CITY OF ALBUQUERQUE

**Re: CVS Pharmacy @ Unser & McMahon, 10700 Unser Blvd. NE,
Request for 90-Day Temporary C.O.—Approved
Engineer's Stamp dated: 05/07/10 & 7-5-11, (A-11/D011)
Certification dated: 08-24-11**

Prior to Permanent Certificate of Occupancy the following items will need to be addressed:

C202

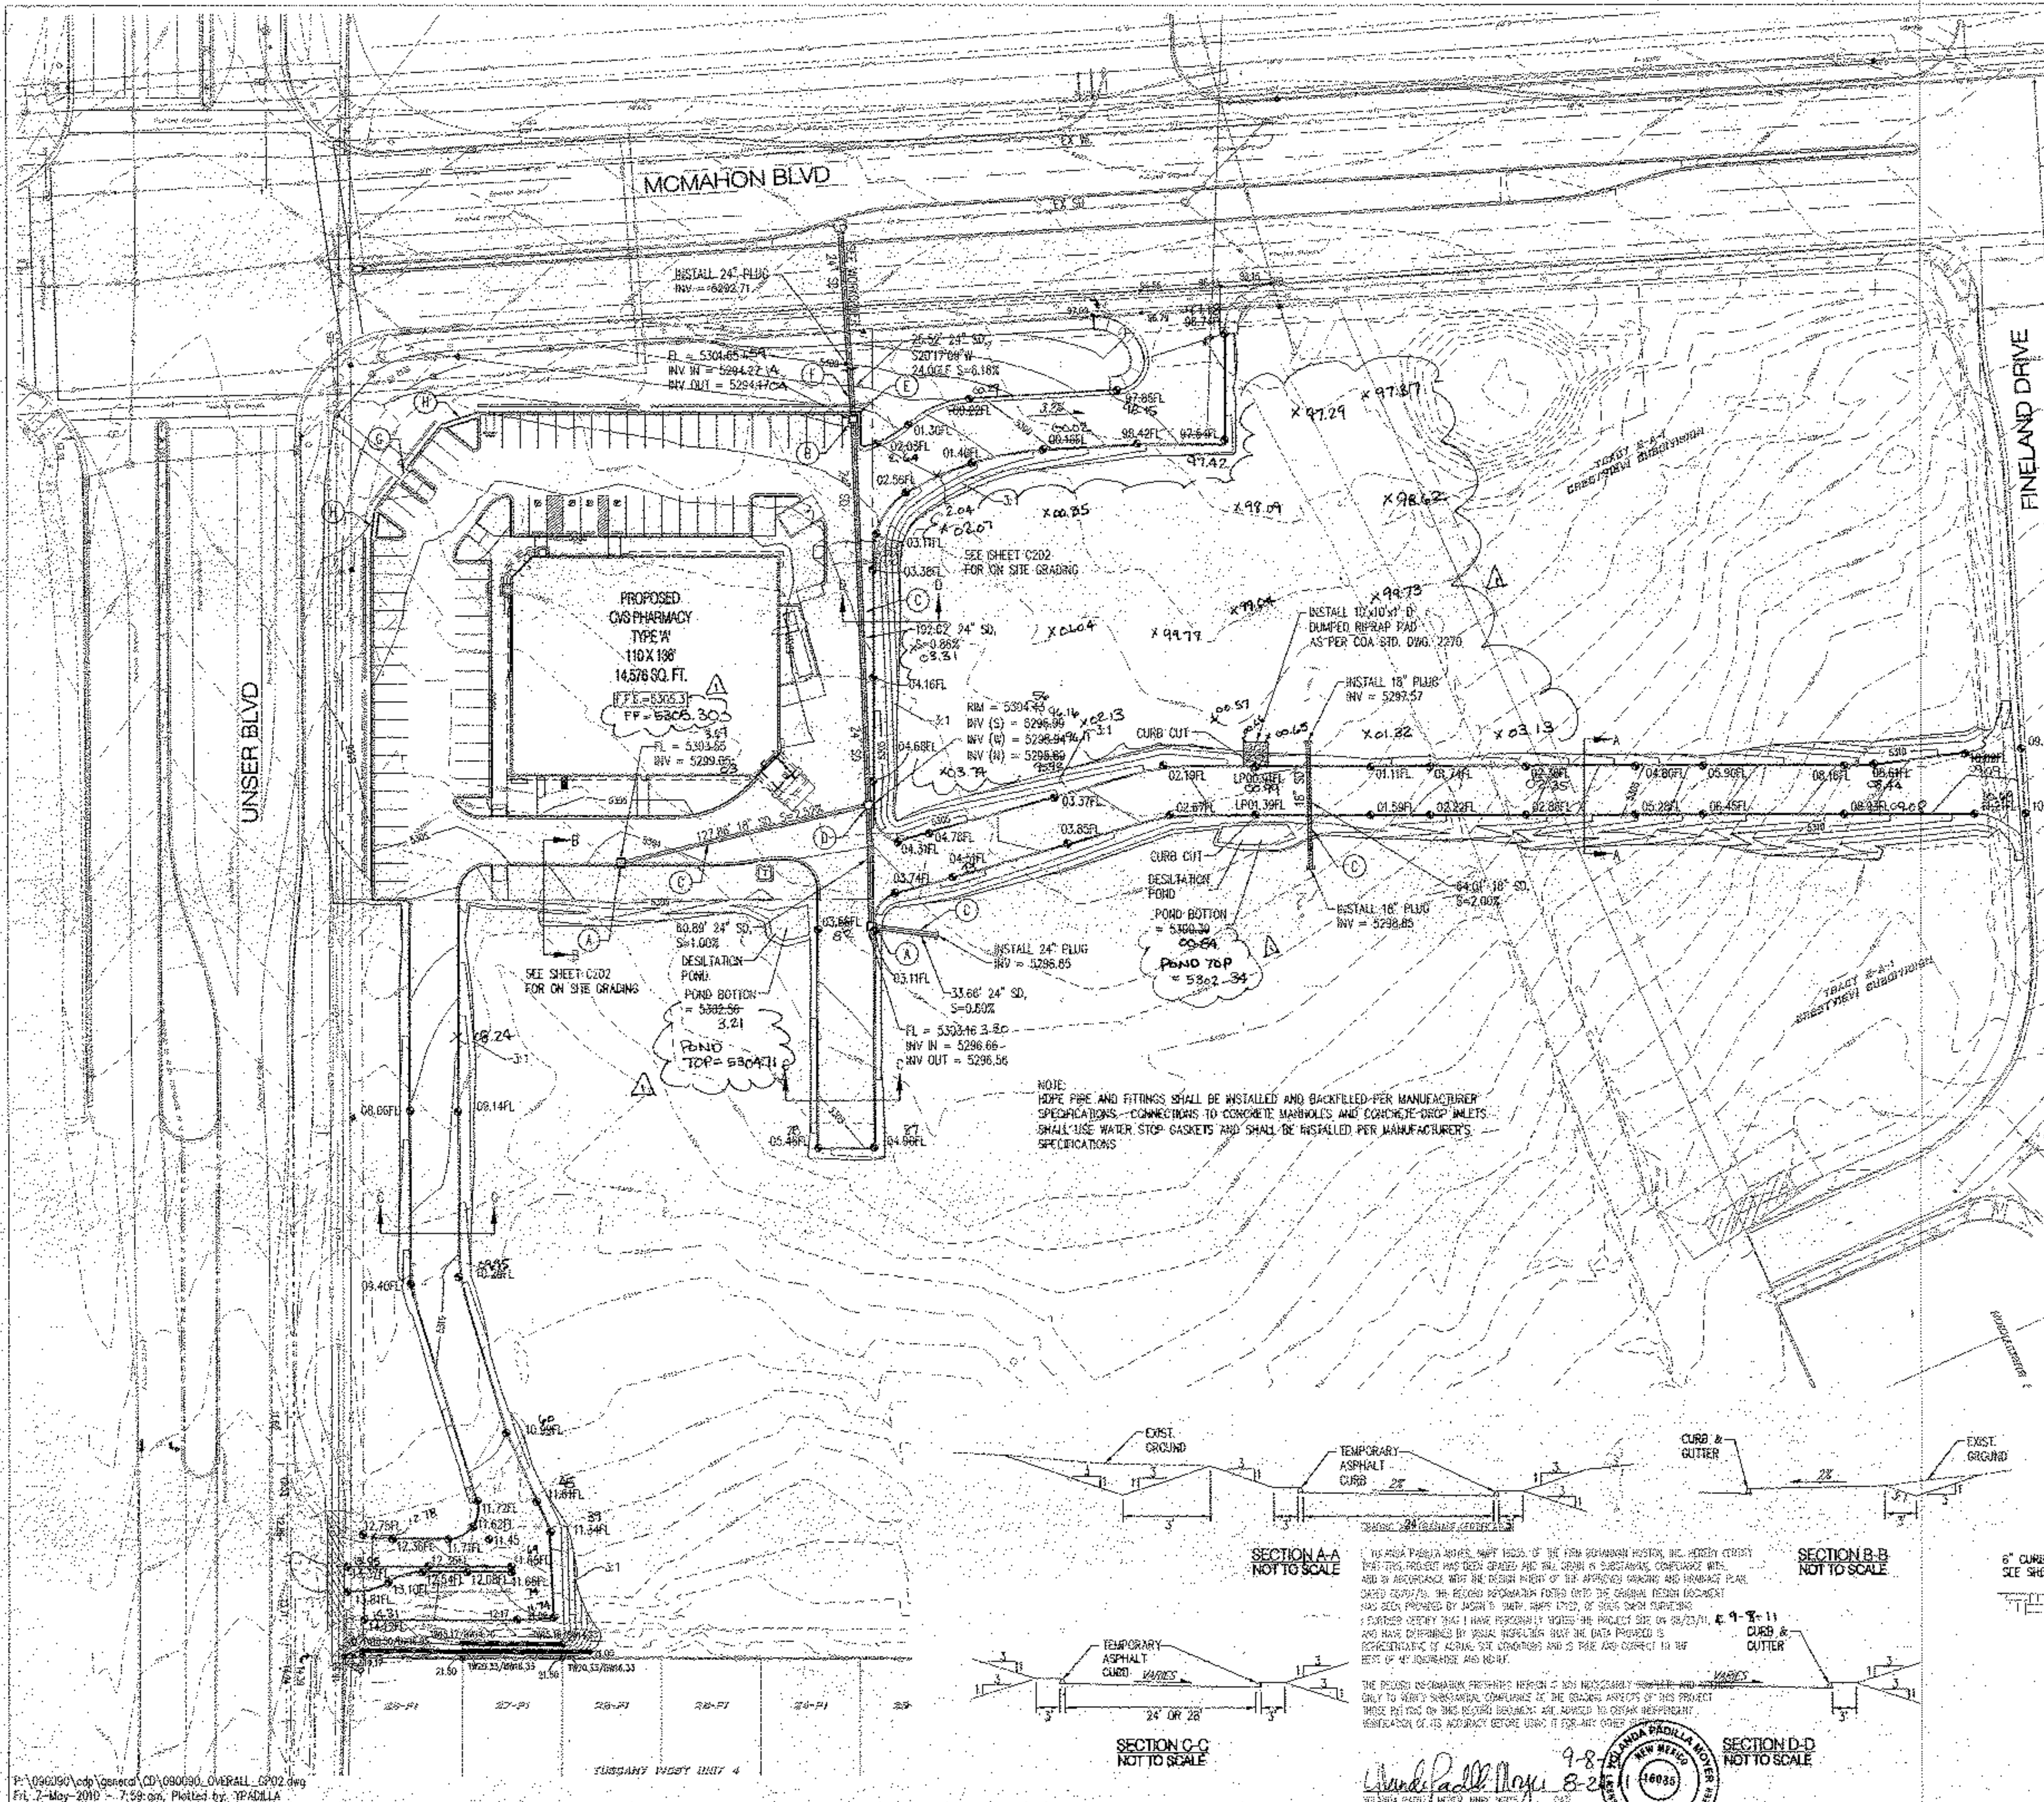
1. After a recent site visit, there is a large spoil pile on the south west side of the site that will need to be removed. This was not identified on the Certification.
2. Please provide the building's finished floor elevation. Please provide bottom of pond elevations and top of pond elevations.
3. All inlets will need to be cleaned from debris.
4. The rip-rap pad will need to be completed.
5. It appears there was some grading activity taking place on east of the building; please include some elevations for the work being done directly to the east of this building.
